**Planning Department
Transportation Development Services**

April 13, 2015

**Re: Innova Plaza
401 Eubank Blvd., SE
Traffic Circulation Layout
Engineer's/Architect's Stamp dated 4-7-15(L20-D067)**

SHEET NUMBER
C-1.0

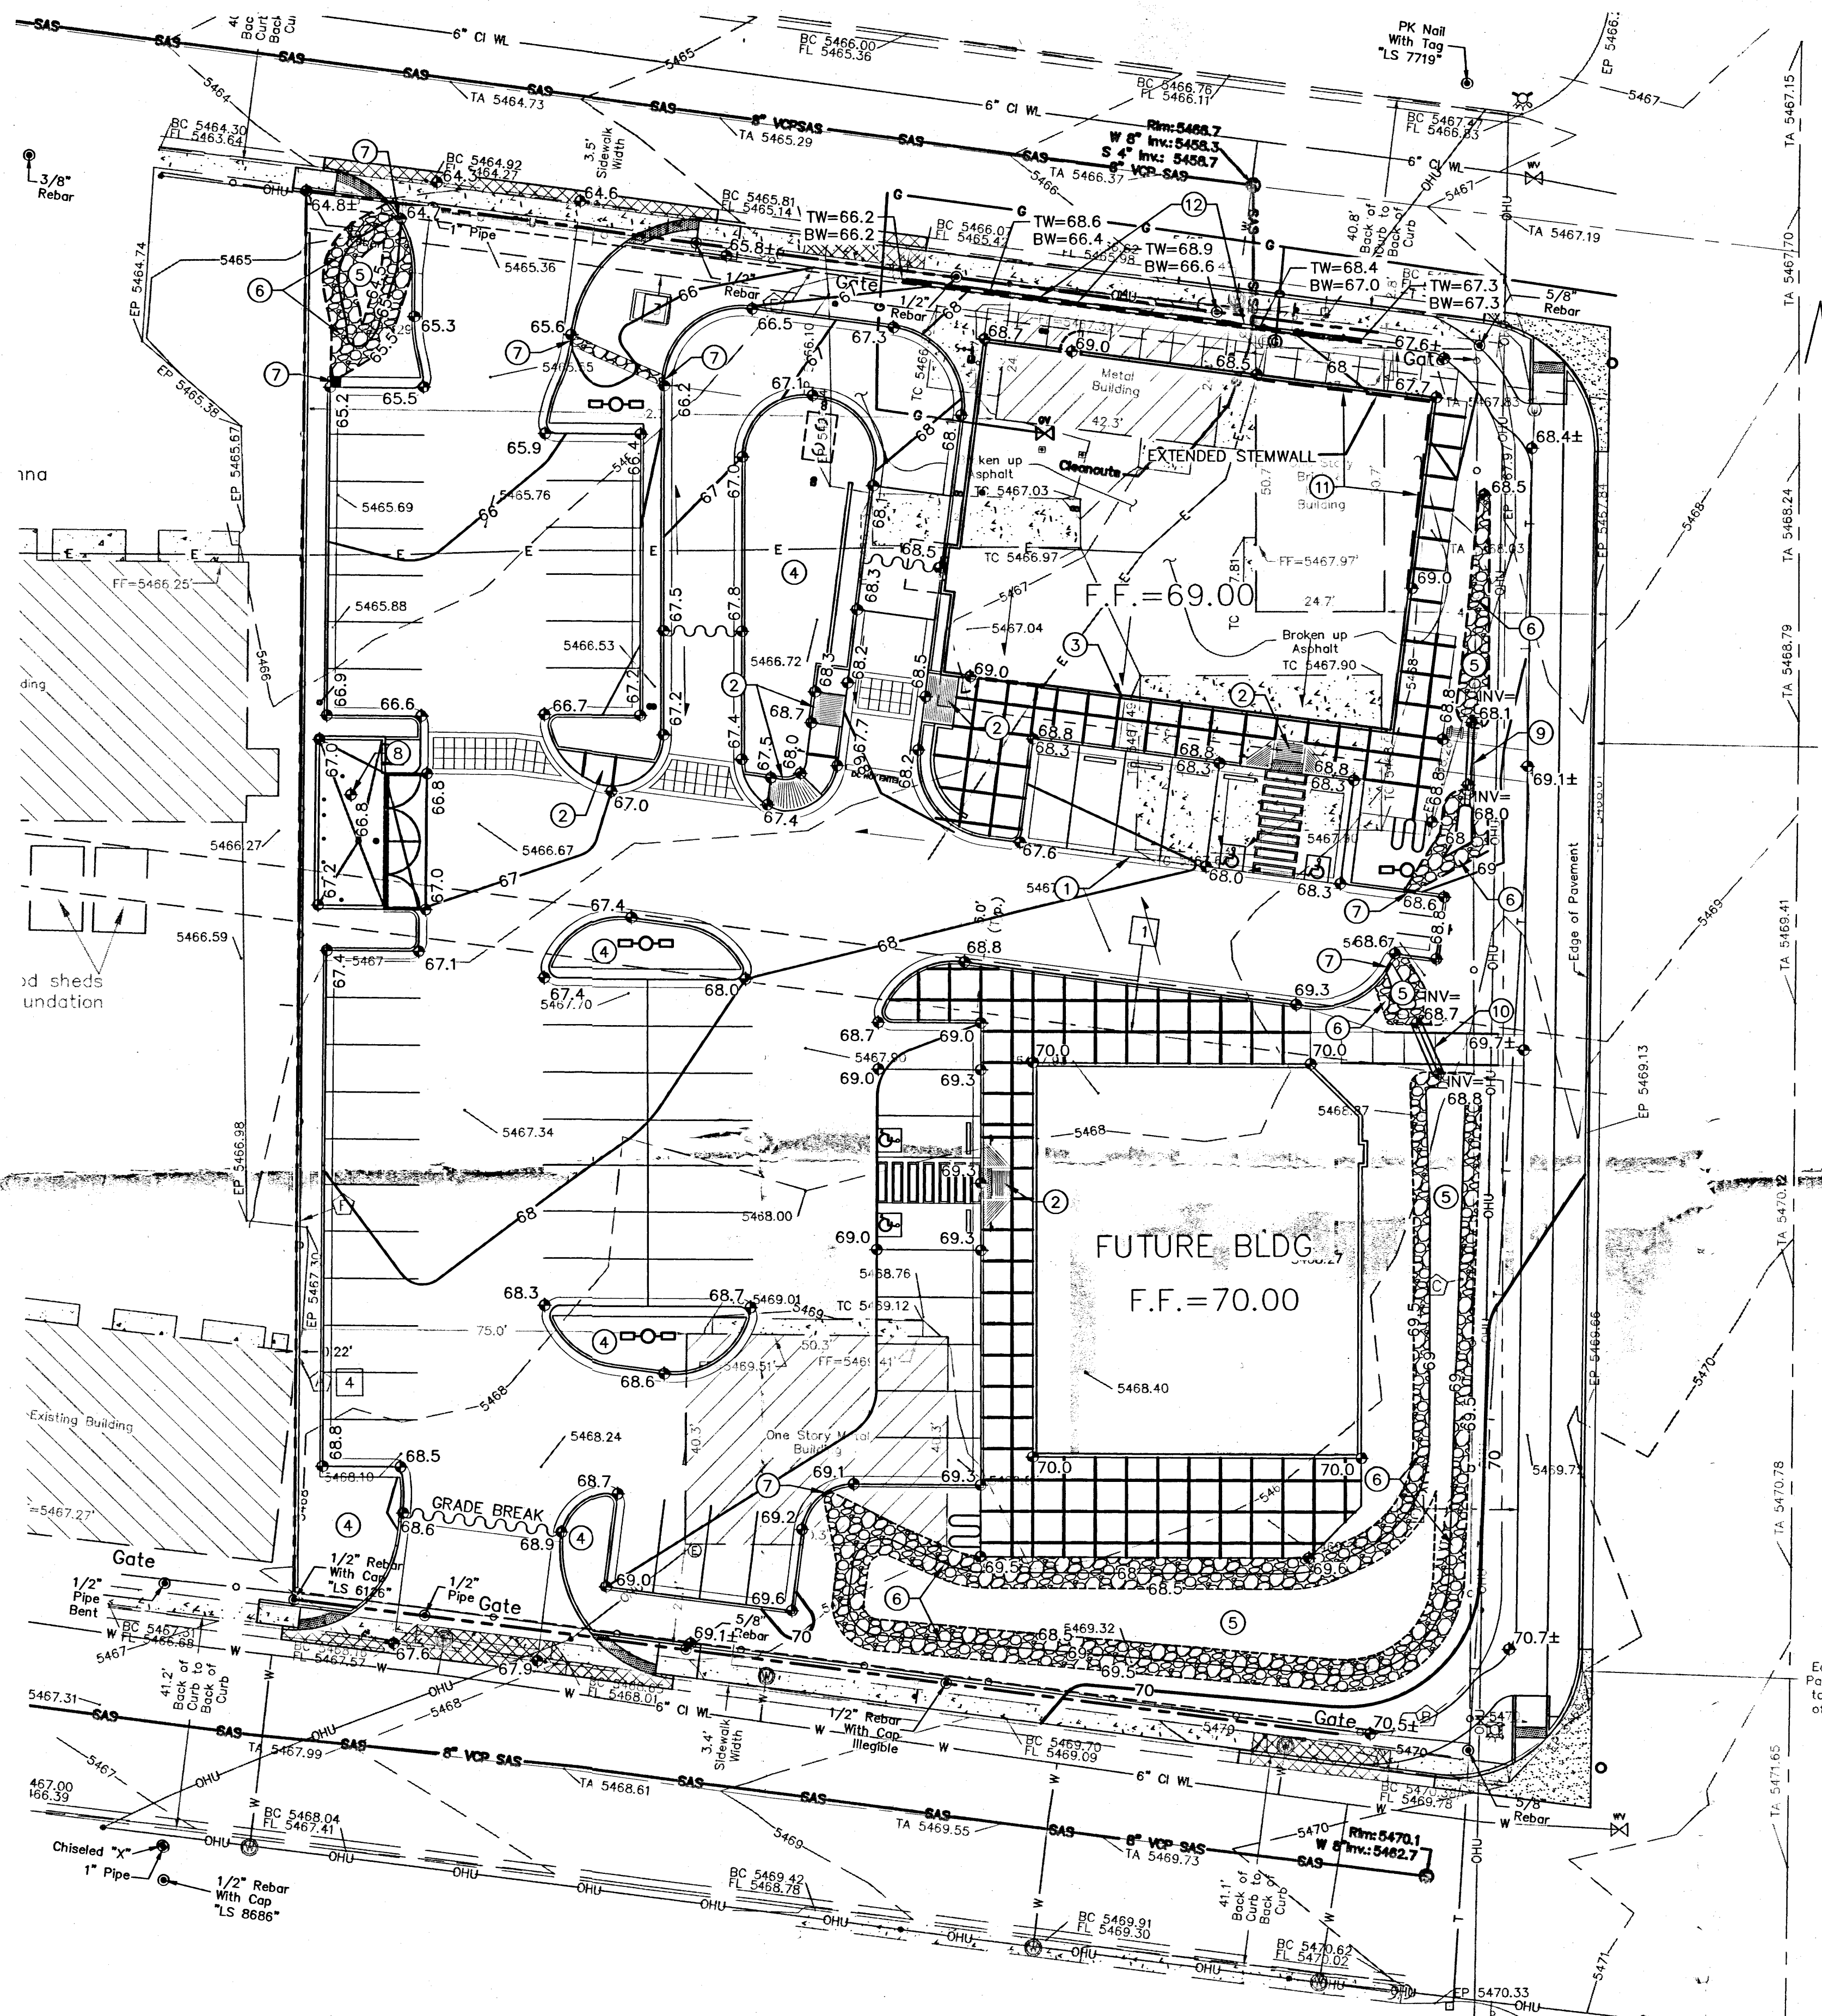
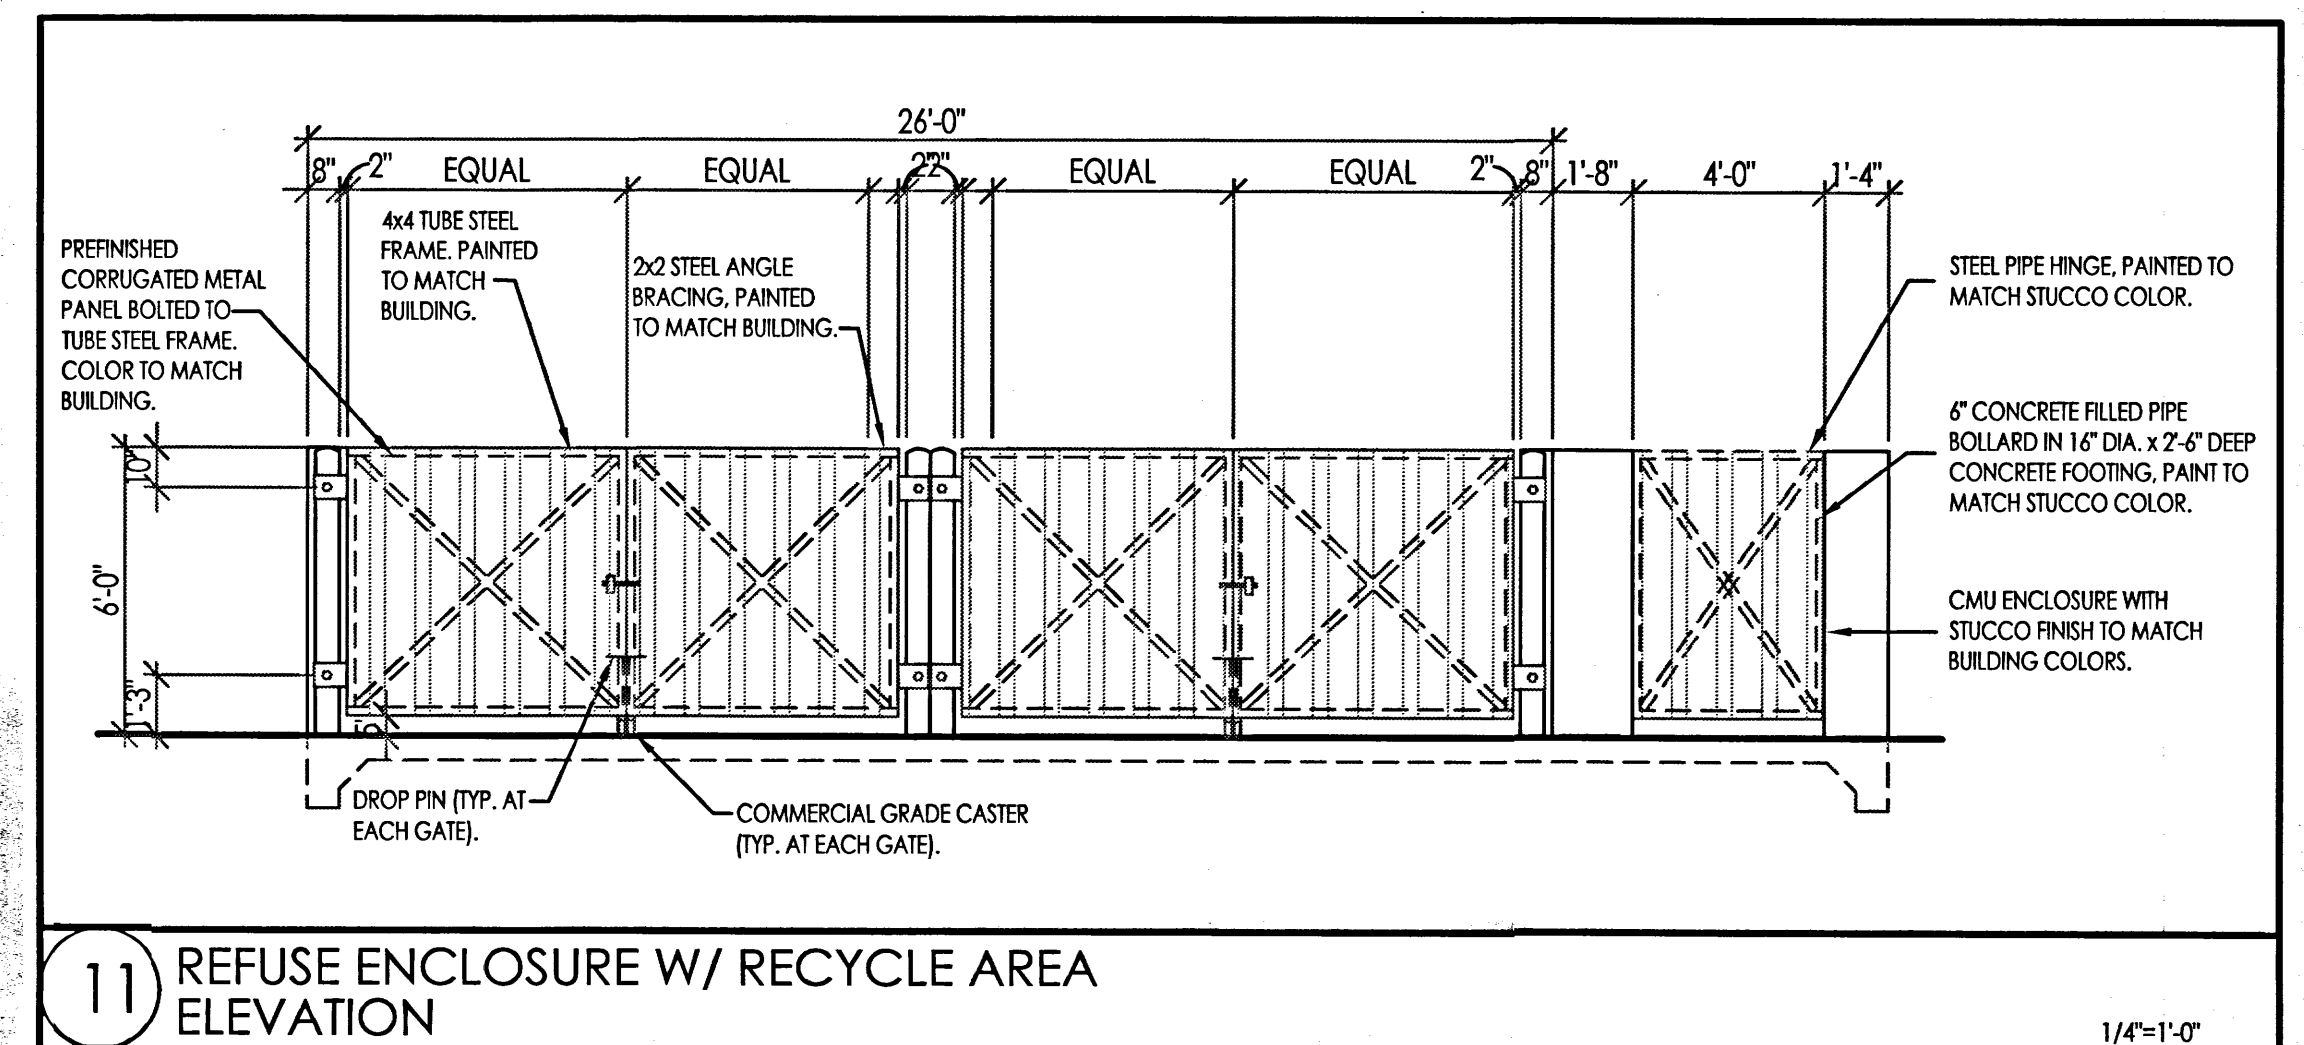
1. Upon review, re-platting of property will be required, so application must be submitted through the DRB Process for approval. If this is complete provide, please the DRB Project number.

2. Label the compact parking spaces by placing the words "**COMPACT**" on the pavement of each space.
3. Please dimension and detail all handicap and pedestrian walkways.

4. The ADA access aisle shall have the words "**NO PARKING**" in capital letters, each of which shall be at least one foot high and at least two inches wide, placed at the rear of the parking space so as to be close to where an adjacent vehicle's rear tire would be placed. (66-1-4.1.B NMSA 1978)

5. Design delivery vehicle route needs to be shown.
6. Service vehicle and/or refuse vehicle maneuvering must be contained on-site; provide a copy of refuse approval (if applicable).

7. Please show the "Clear Site Triangle" at the two entrance points per D5, Chapter 23 of the DPM.
8. Please include a copy of your shared access and parking agreement with the adjacent property owner. (If applicable)

10. Unused curb cuts must be replaced with sidewalk and curb & gutter. A build note must be provided referring to the appropriate City Standard. Please add detail of existing curb cuts on Trumbull Ave. and Bell Ave. that are to be removed and replaced with sidewalk per COA Standard #2430.
11. Please include two copies of the traffic circulation layout at the next submittal.
